# Rosefield Solar Farm

## Notification of Proposed Change

EN010158/APP/8.15  
Revision 01  
May 2026  
Rosefield Energyfarm Limited

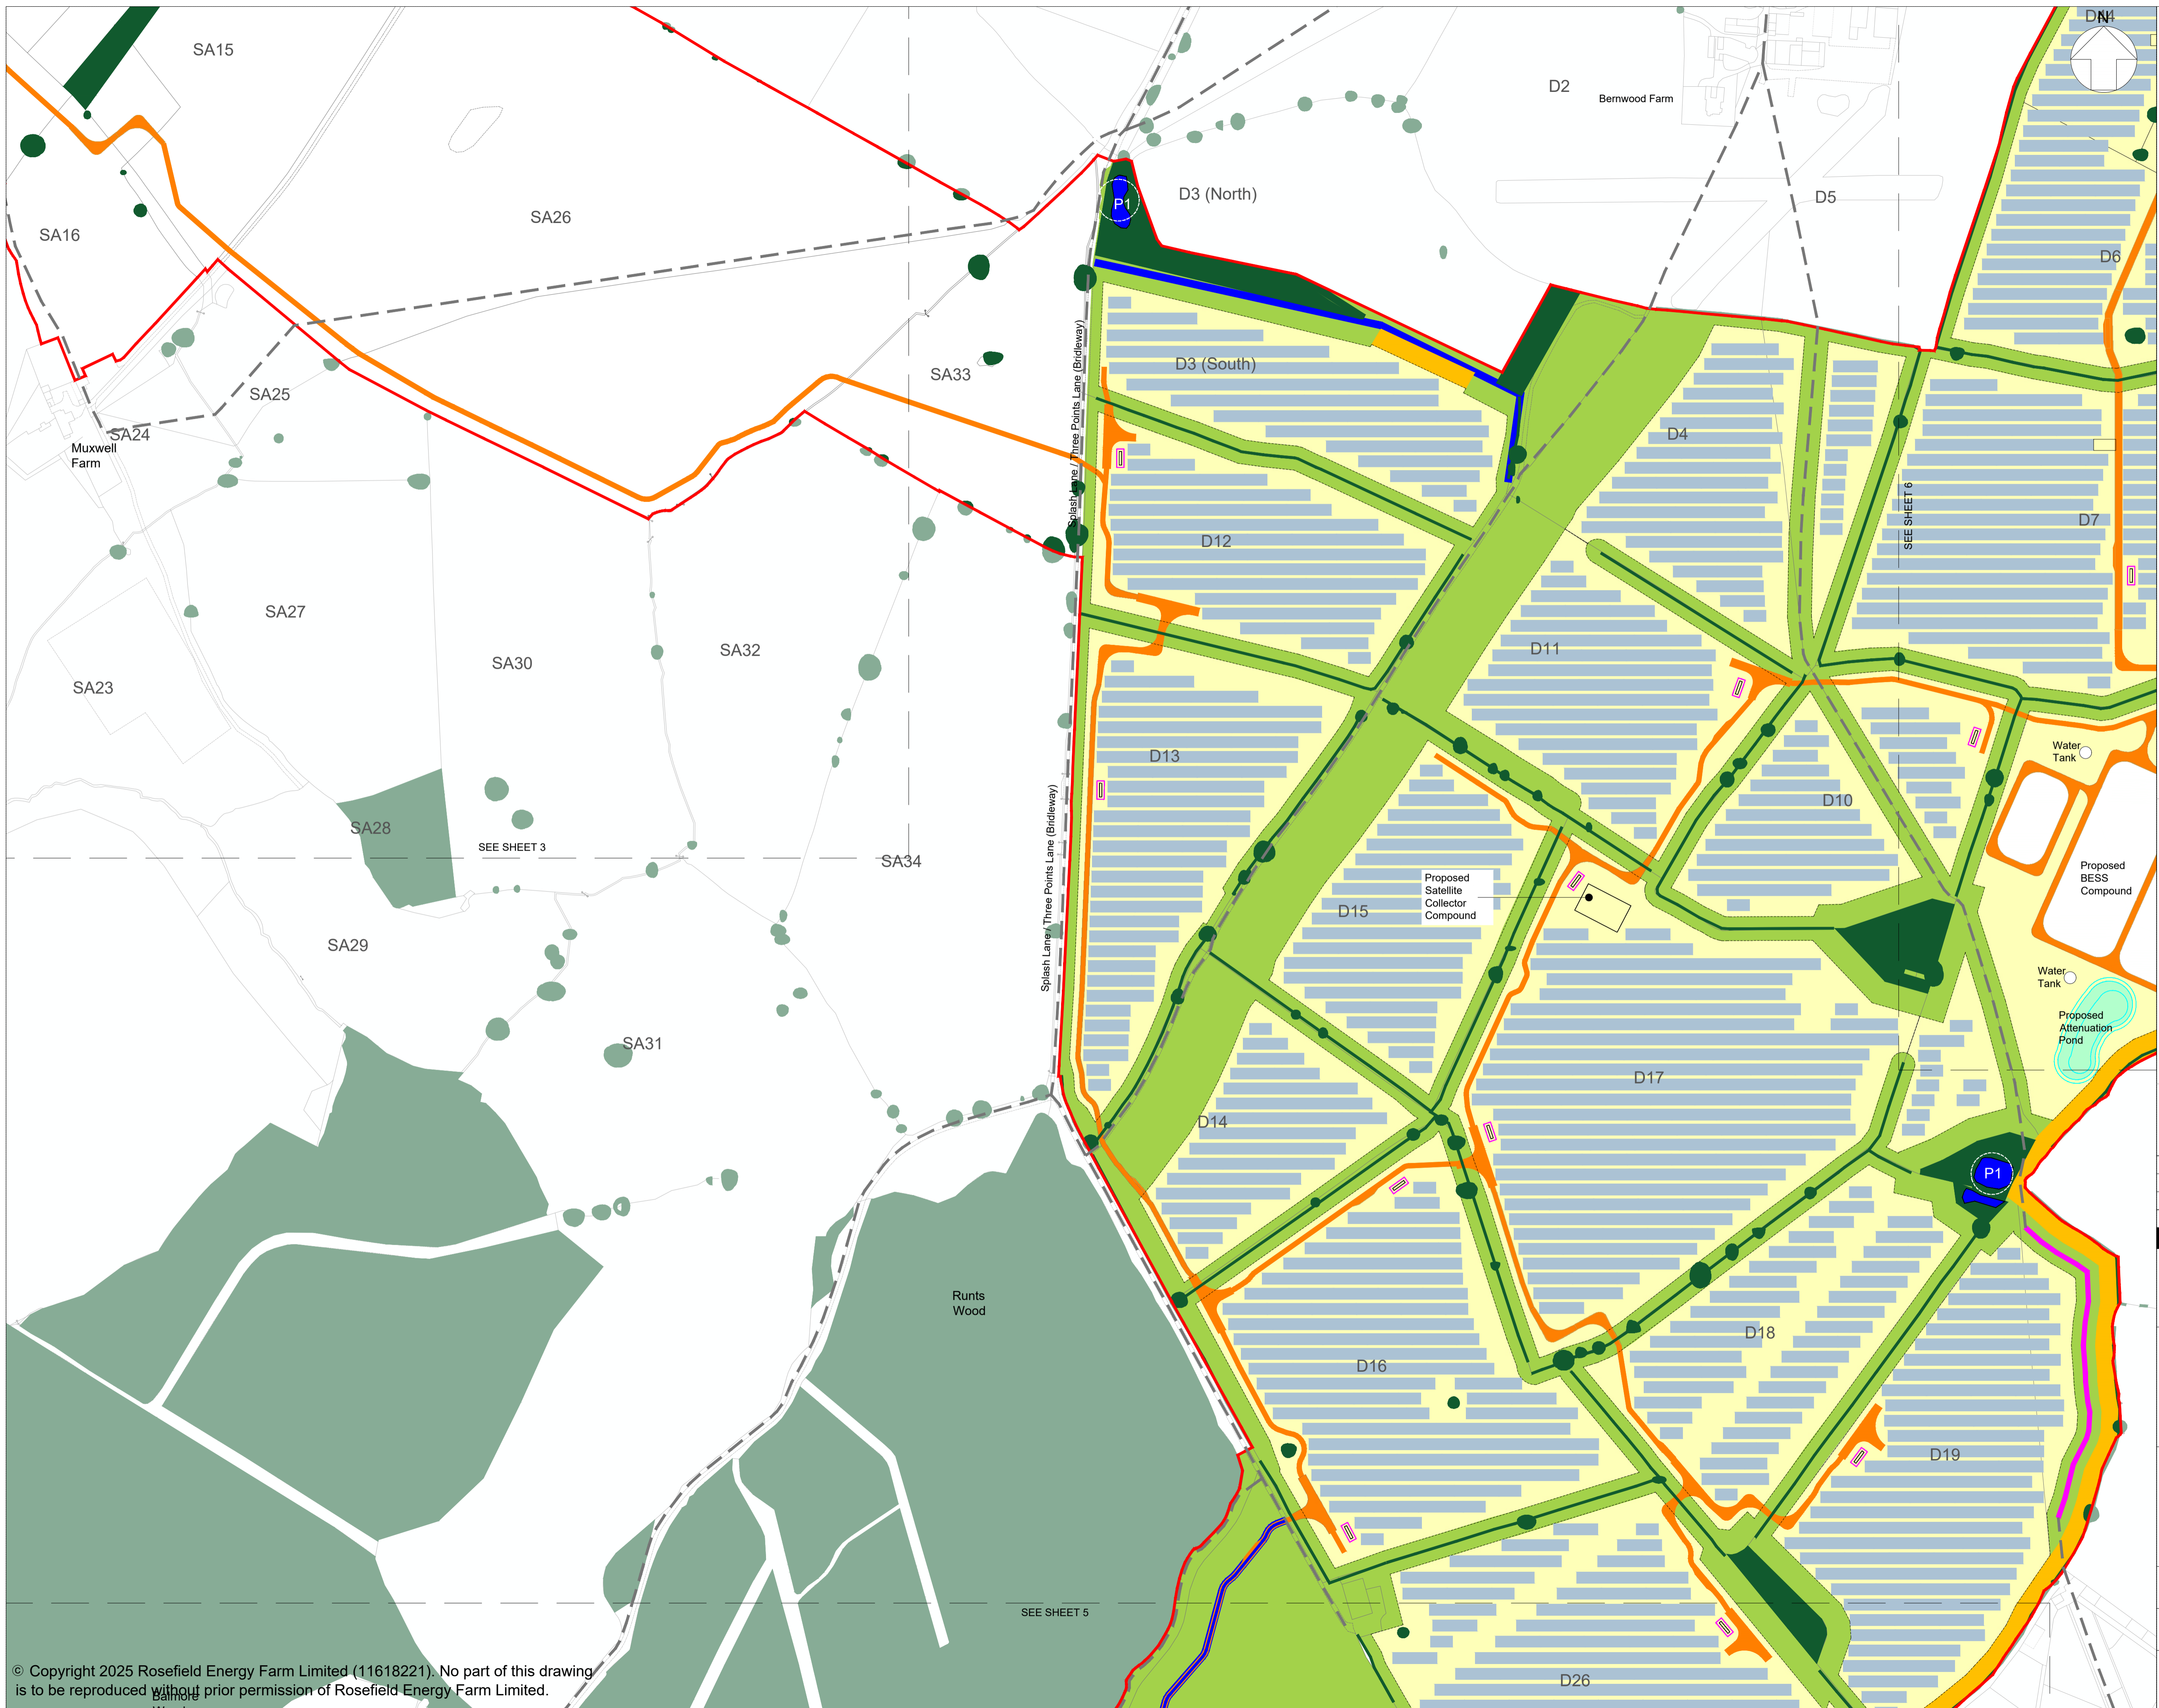
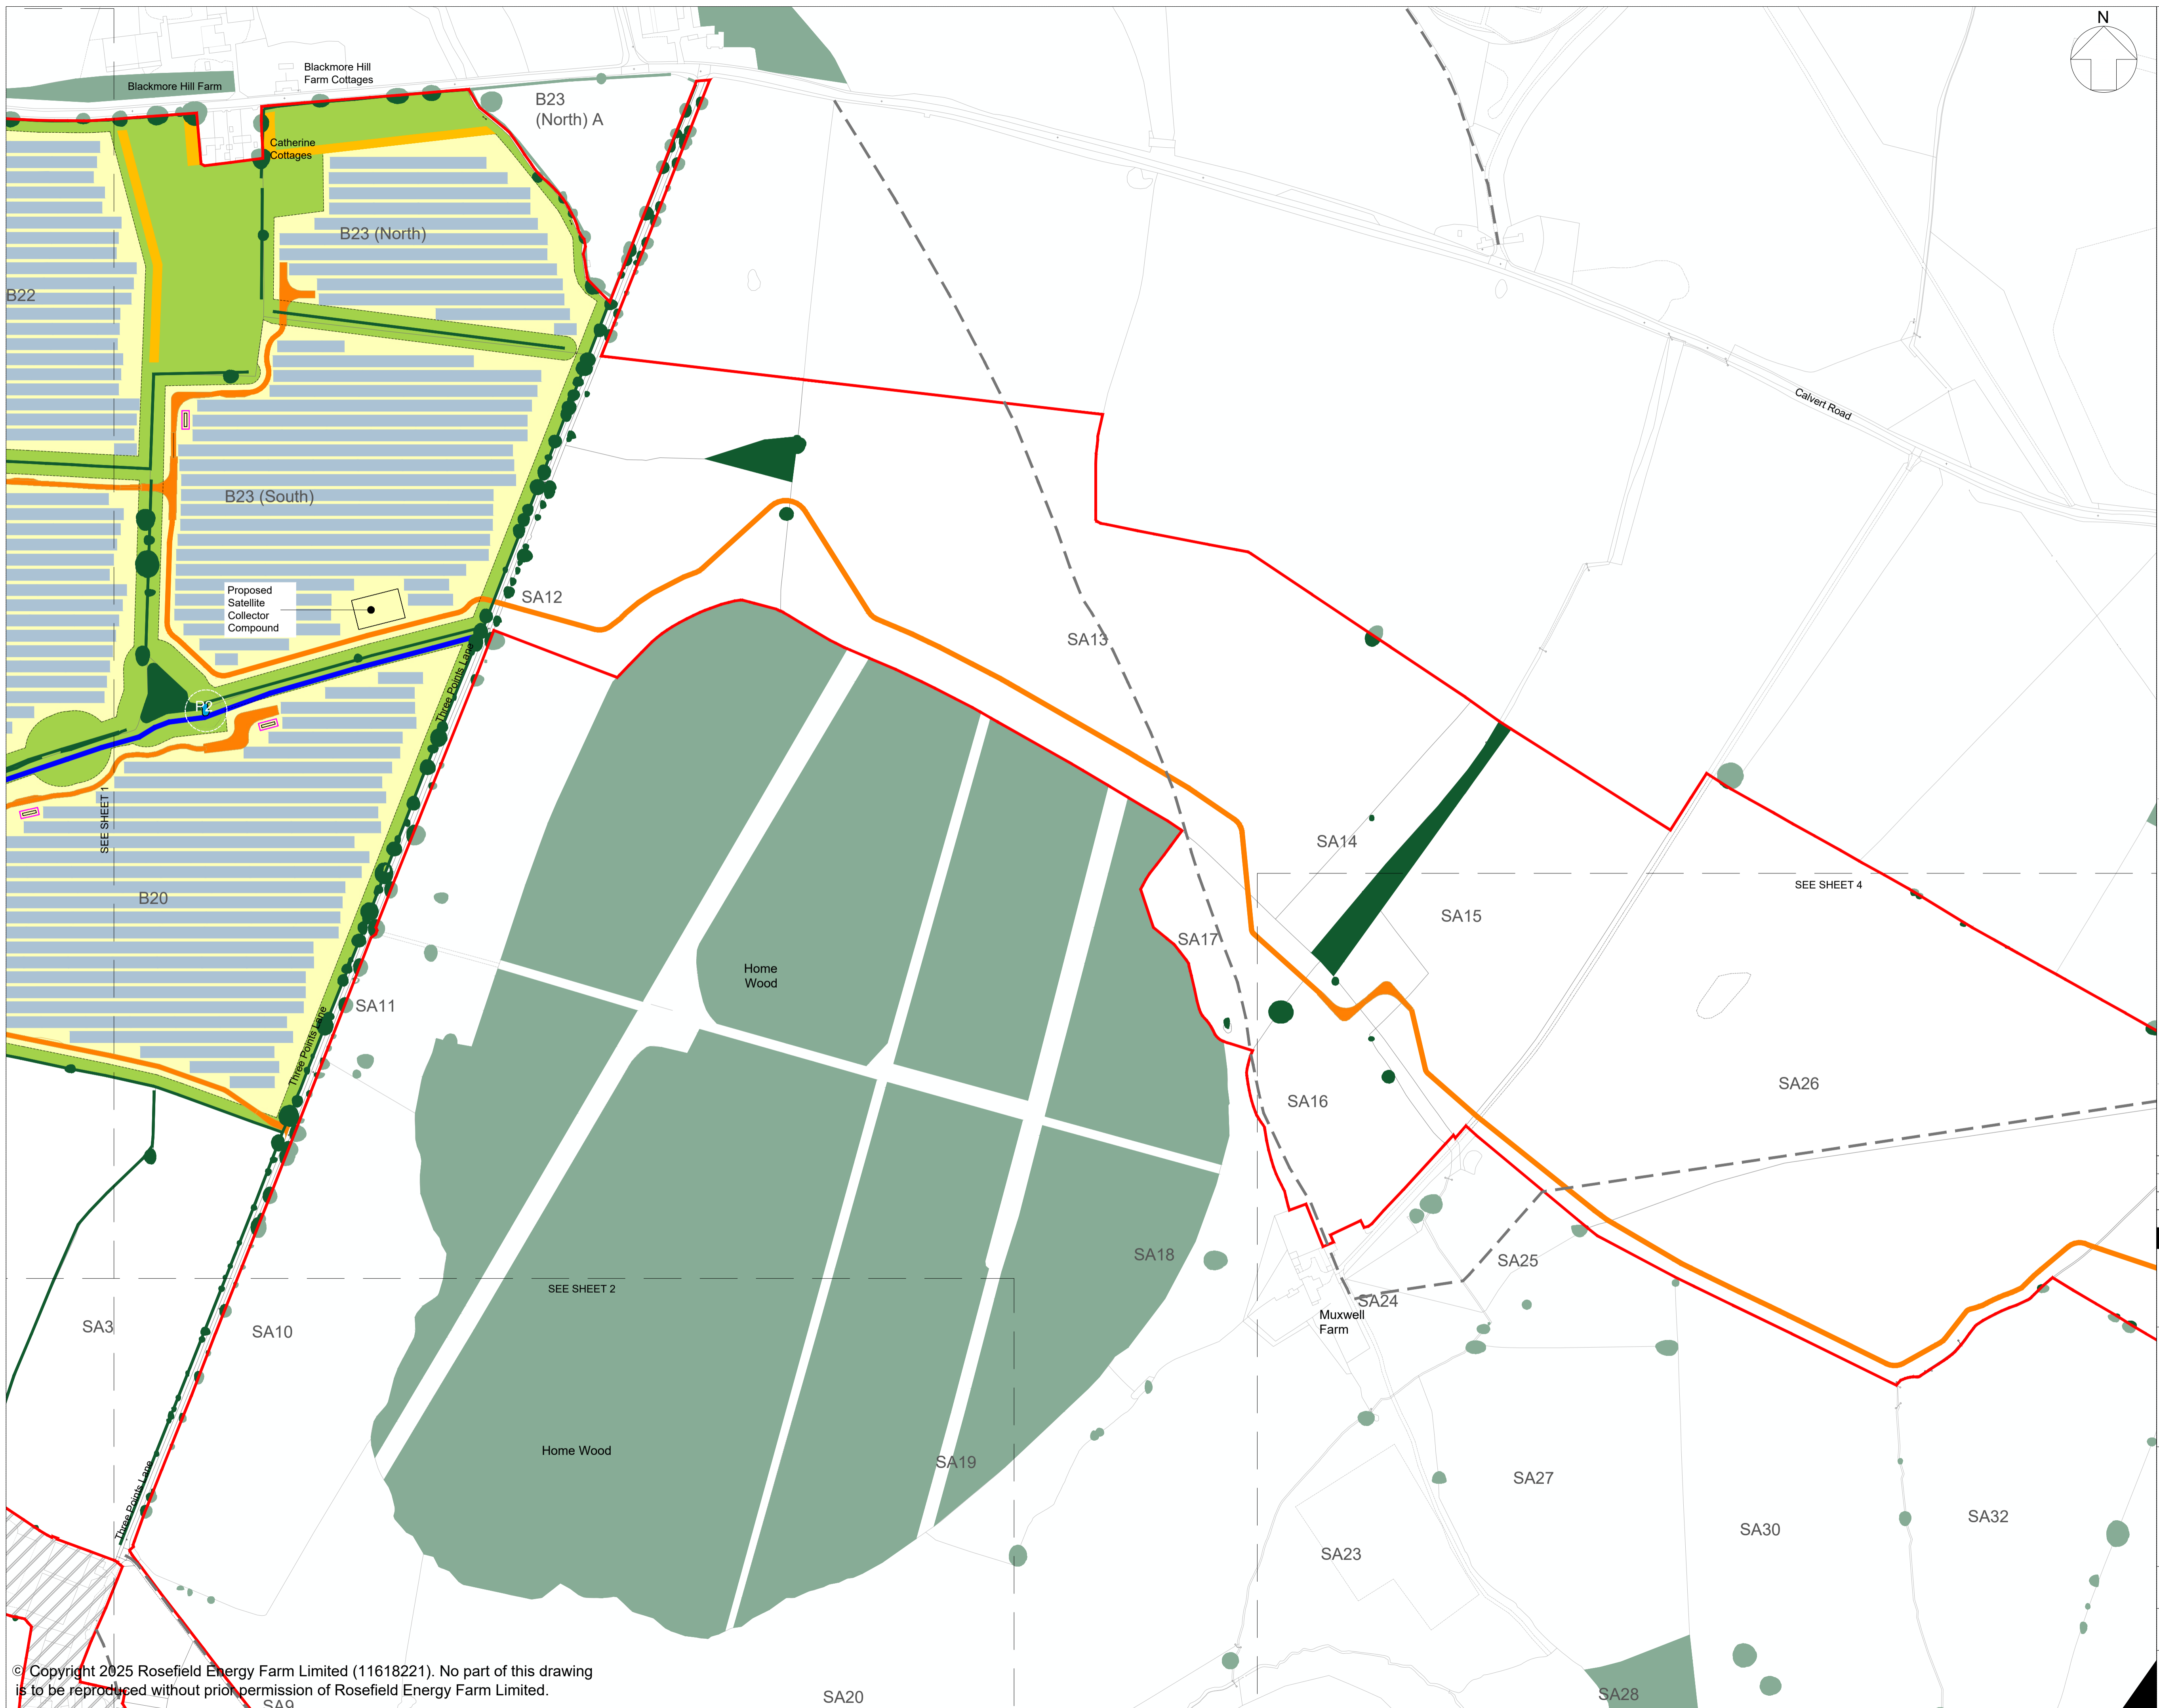
- 2.2.1. The Proposed Change would deliver a bridleway link across Parcel 2, which would be accessible to the public during the operation (including maintenance) phase of the Proposed Development. It would connect the existing dead-end PRow Bridleway (reference 'ECL/10/5') to the north of Field D27 to the PRow Bridleway (reference 'QUA/40/2' and 'QUA/40/3') that runs along the southern edge of Fields D28 and D29, addressing the “missing link” in the bridleway network identified by Buckinghamshire Council. Please refer to Appendix A of this document for a plan showing the location of the Proposed Change.

- 2.2.2. The proposed bridleway link would run south west along the proposed internal access track through Field D27 and then along PRow Footpath (reference 'QUA/41/1') through Field D28. The total distance of the link would be approximately 0.9 km long, of which 0.3 km follows the alignment of PRow Footpath reference 'QUA/41/1'.
